Planning Applic. No 3/2024/0754

Proposal: Prop. two-storey ext'n to side and rear including conversion of garage & insertion of larger dormer to front roof slope, additional rooflight to rear roof slope.

Location: 86, Whalley Road, Langho, BB6 8EQ.

Client: Andrew Carney		
Project: Proposed Alterations 86 Whalley Road Langho		
Dwg title: Proposed Side Elevation (NE)		
Scale @ A4: 1:50	Date: 10.08.24	Drawn by: PD
Drawing no. 1642 - 11	Rev. -

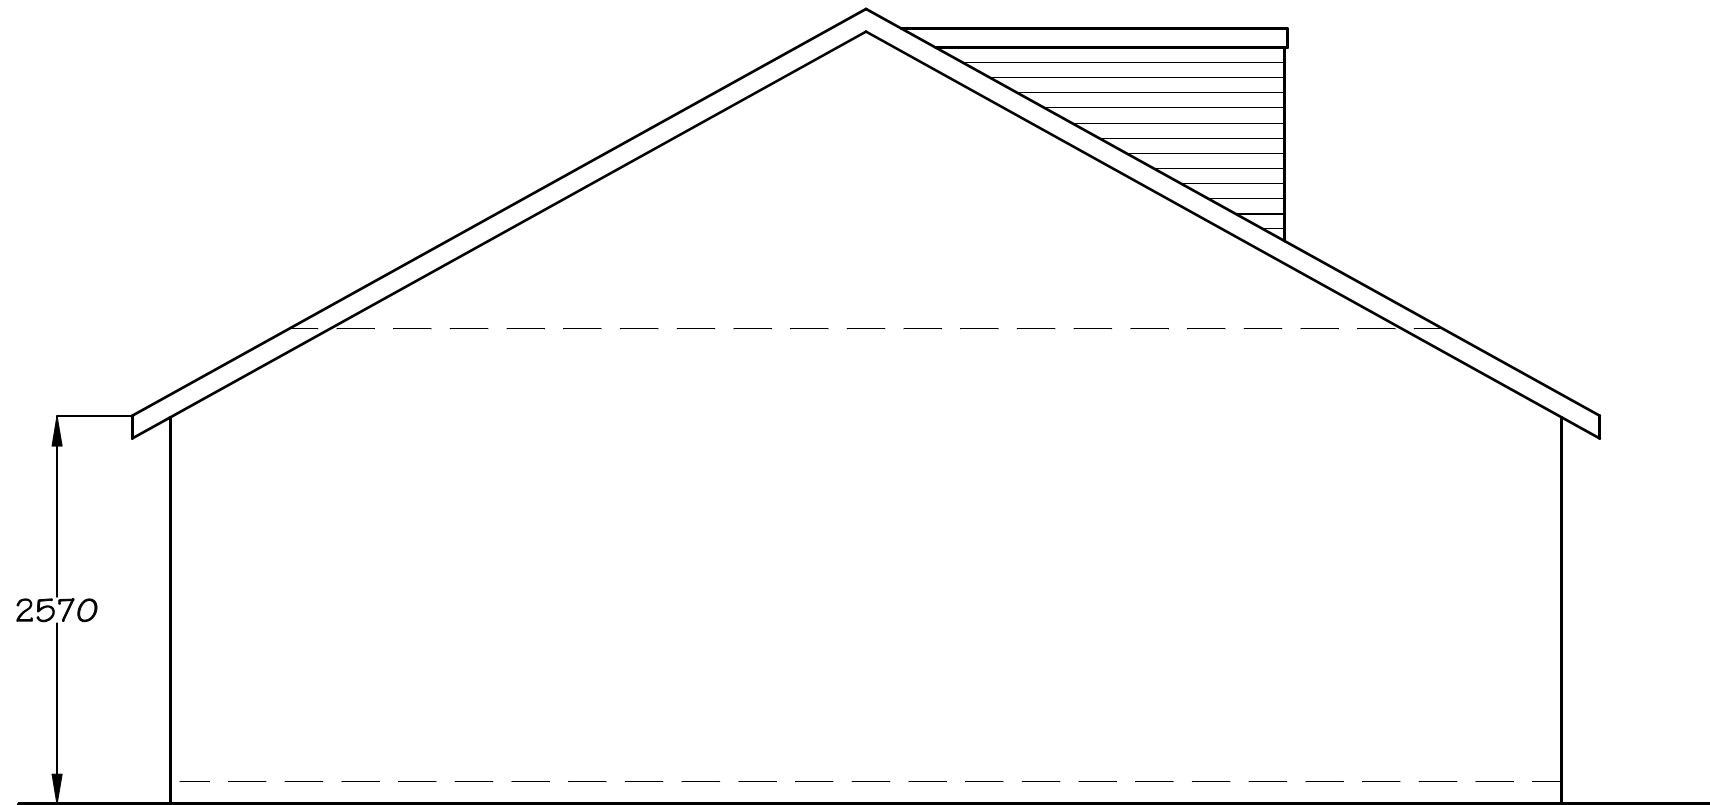
Proposed Side Elevation NE is erroneously shown as 1642-04
~ Existing Side elev. NE.
